CITY OF ALBUQUERQUE

August 10, 2011

Re: Pond J Grading Plan

Engineer's Stamp dated 8-9-11 (C9/D001B)

Design Review Committee City Engineer Approval  
 Mo./Day/Yr. \_\_\_\_\_  
 City of Albuquerque Public Works Department  
**CANTATA AT THE TRAILS**  
 POND & GRADING PLAN

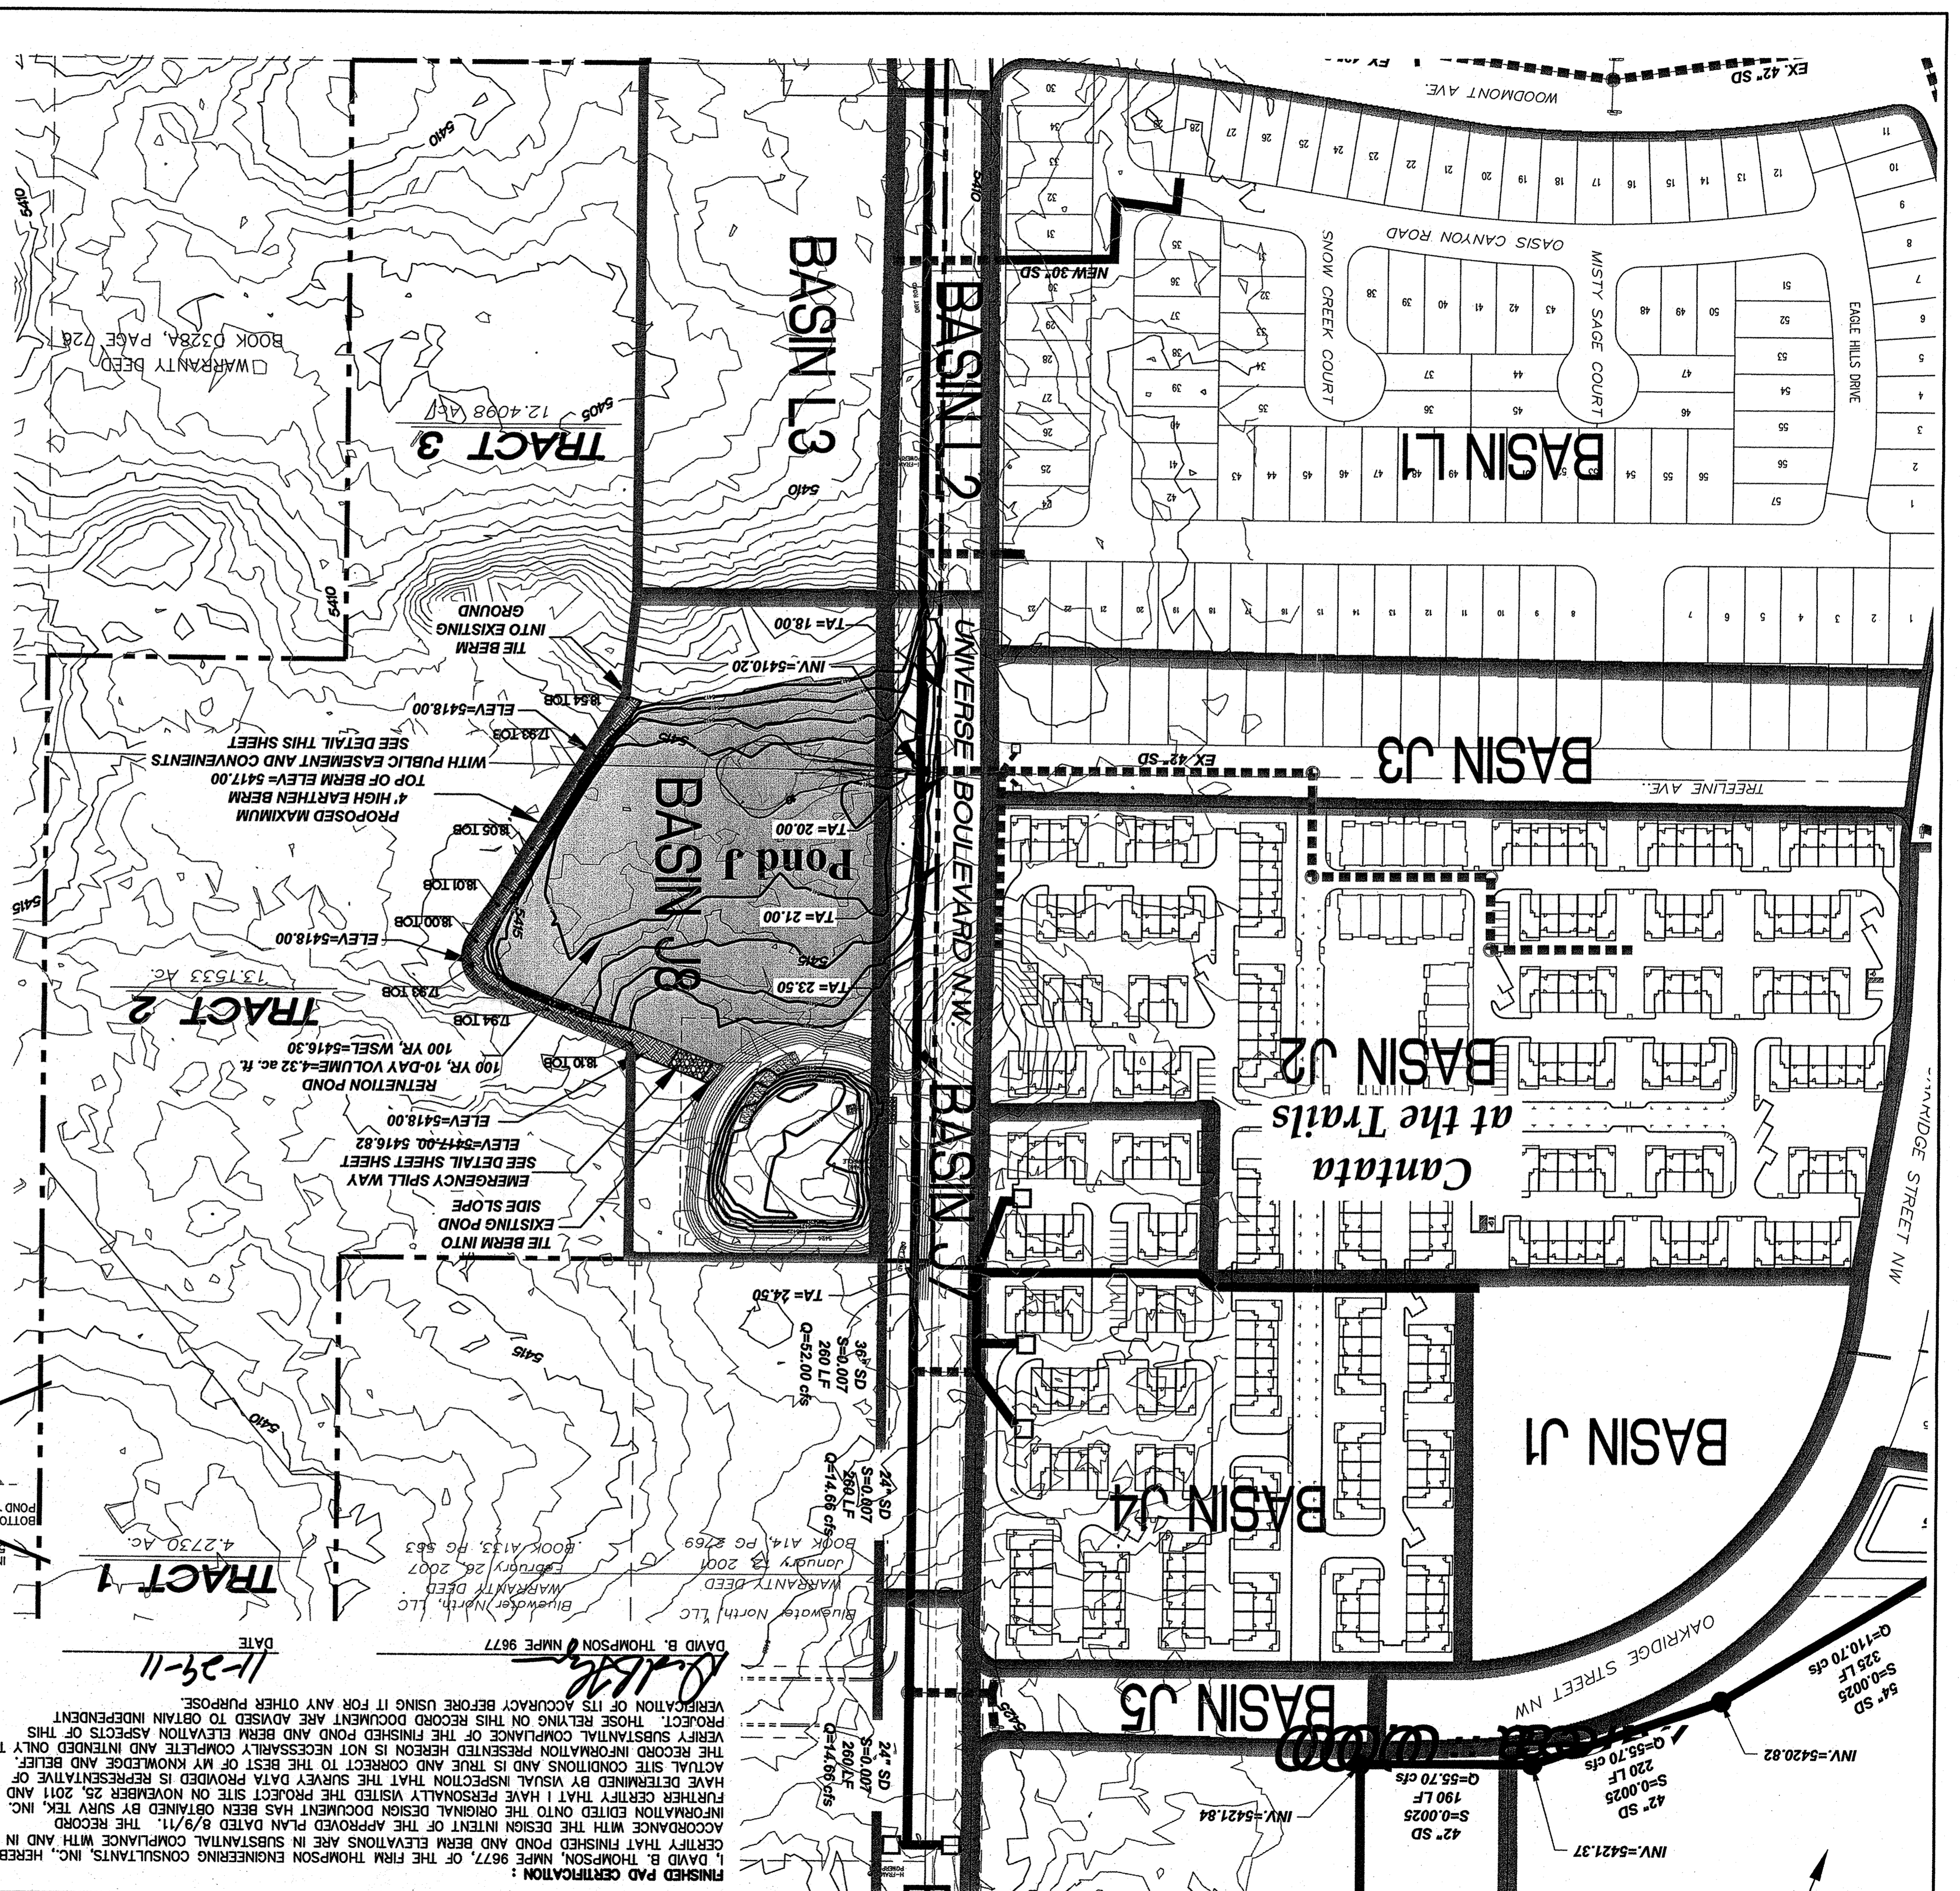
This letter does not approve installation of Proposed Storm Drain shown on the plan.

In addition, if the slope from Universe Blvd is steeper than 3:1 it will require an engineered means of erosion control. The slope created must meet roadside design guidelines or a guardrail or similar may be required.

Certification of this Grading plan is required prior to issuance of Building Permits in the area designated as Basin J2. When submitting the Certification, the slope from Universe to the pond is required. This would best be demonstrated by a section at/near the storm drain penetration into the pond. The section should include a portion of the roadway and continue into the bottom of the pond.
